**WELWYN HATFIELD BOROUGH COUNCIL
EXECUTIVE DIRECTOR - PLANNING, PUBLIC PROTECTION AND GOVERNANCE**

DELEGATED APPLICATION

Application No: 6/2016/2730/HOUSE
Location: 1 Stanborough Mews Welwyn Garden City AL8 6DB
Proposal: Erection of extension to existing double garage to form home office
Officer: Ms R Collard

Recommendation: Refused

Drawing; PROPOSED ELEVATIONS/  
FLOOR PLAN & SITE PLAN.

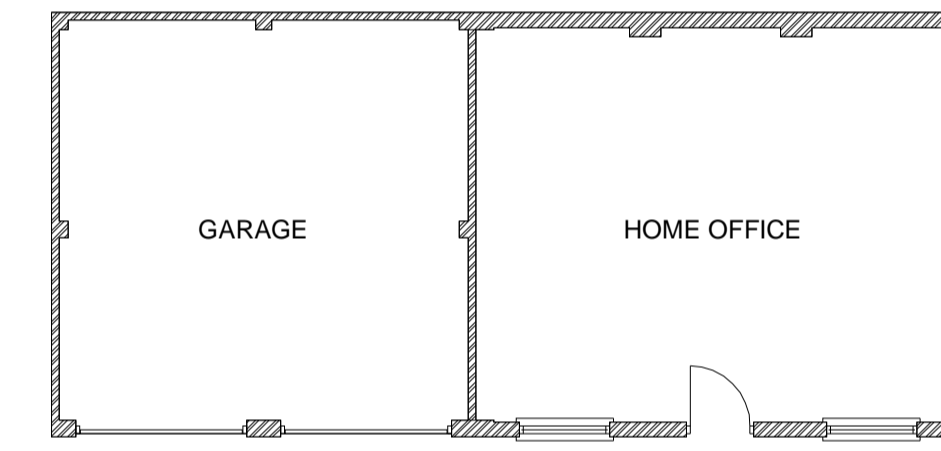
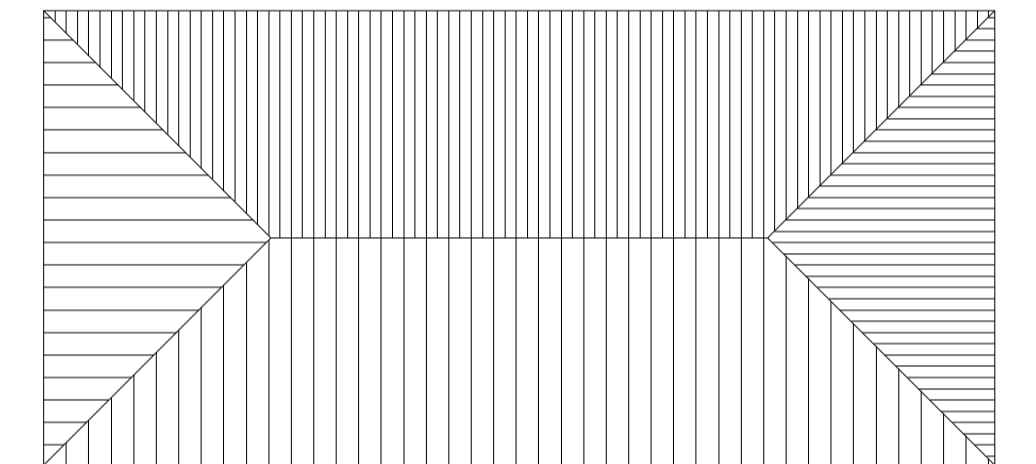
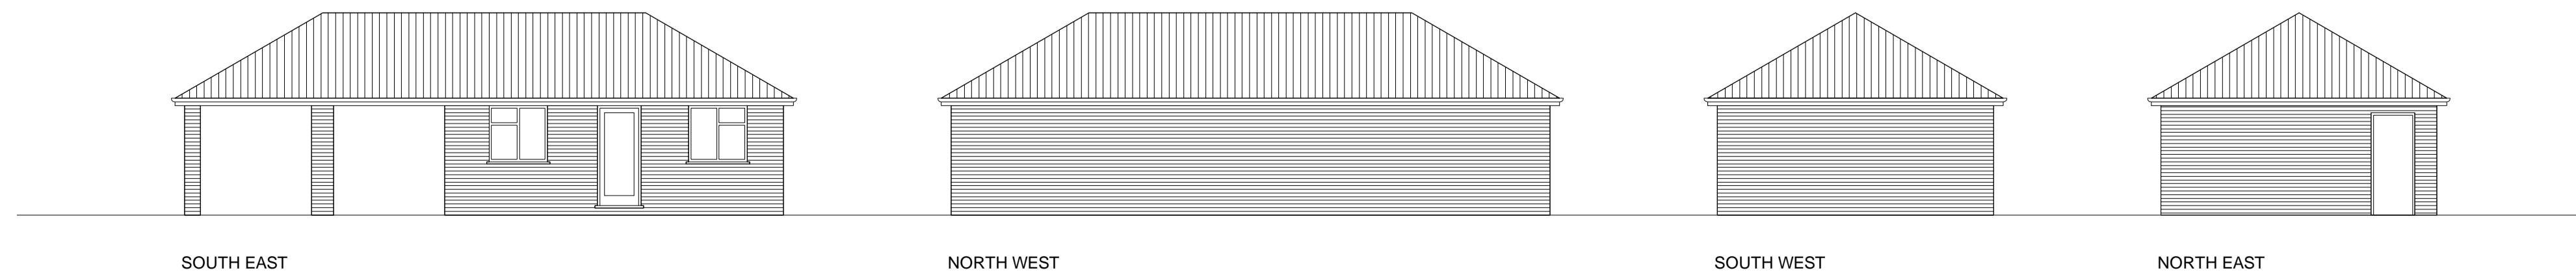
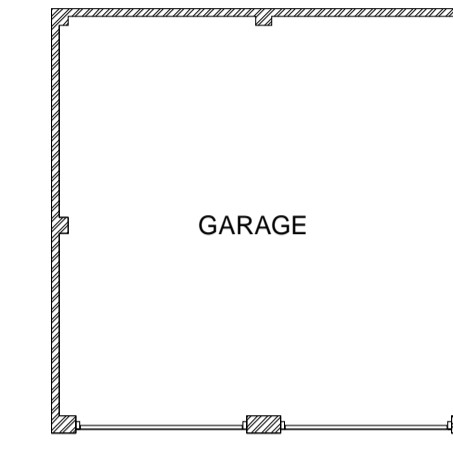
<p>all new development.</p> <p>The proposal would extend the existing garage across the full width of the plot and would be located on the boundary with No.3 Stanborough Mews. It is considered that the size, scale, bulk and mass of the resultant building together with its siting directly on the boundary would have a poor relationship with the neighbouring dwelling, resulting in an overbearing and dominant relationship with the neighbouring dwelling, having an adverse impact on their residential amenity.</p> <p>Therefore it is considered that the proposed development would detrimentally harm the amenity of neighbouring dwellings and would not be in accordance with Policy D1 of the Welwyn Hatfield District Plan 2005, SPG and the NPPF</p>
Access, car parking and highway considerations	No changes would be made to the existing parking, therefore no objections are raised.
Landscaping Issues	None

1. The proposed development, by virtue of its siting, scale and design would result in a substantially large built form that failed to be subordinate to the main dwelling and as a result of its position along the rear boundary of the application site would be readily visible from Longcroft Green and Stanborough Road. Its overall size would have a detrimental impact upon the character and appearance of the area and would result in the overdevelopment of the application site. Accordingly the proposal would be of a poor quality of design which would fail to respect and reflect the immediate street scene contrary to the National Planning Policy Framework and policies D1 and D2 of the Welwyn Hatfield District Plan 2005 and the Supplementary Design Guidance, Statement of Council Policy 2005.

2. The proposed development, by virtue of its scale, height and siting would result in an overbearing and dominant relationship with the neighbouring dwelling, No.3 Stanborough Mews, and as a result would have an adverse impact to their residential amenity. The proposal therefore represents a poor standard of design contrary to Policy D1 of the Welwyn Hatfield District Plan 2005, guidance under the Supplementary Design Guidance, Statement of Council Policy 2005 and the National Planning Policy Framework.
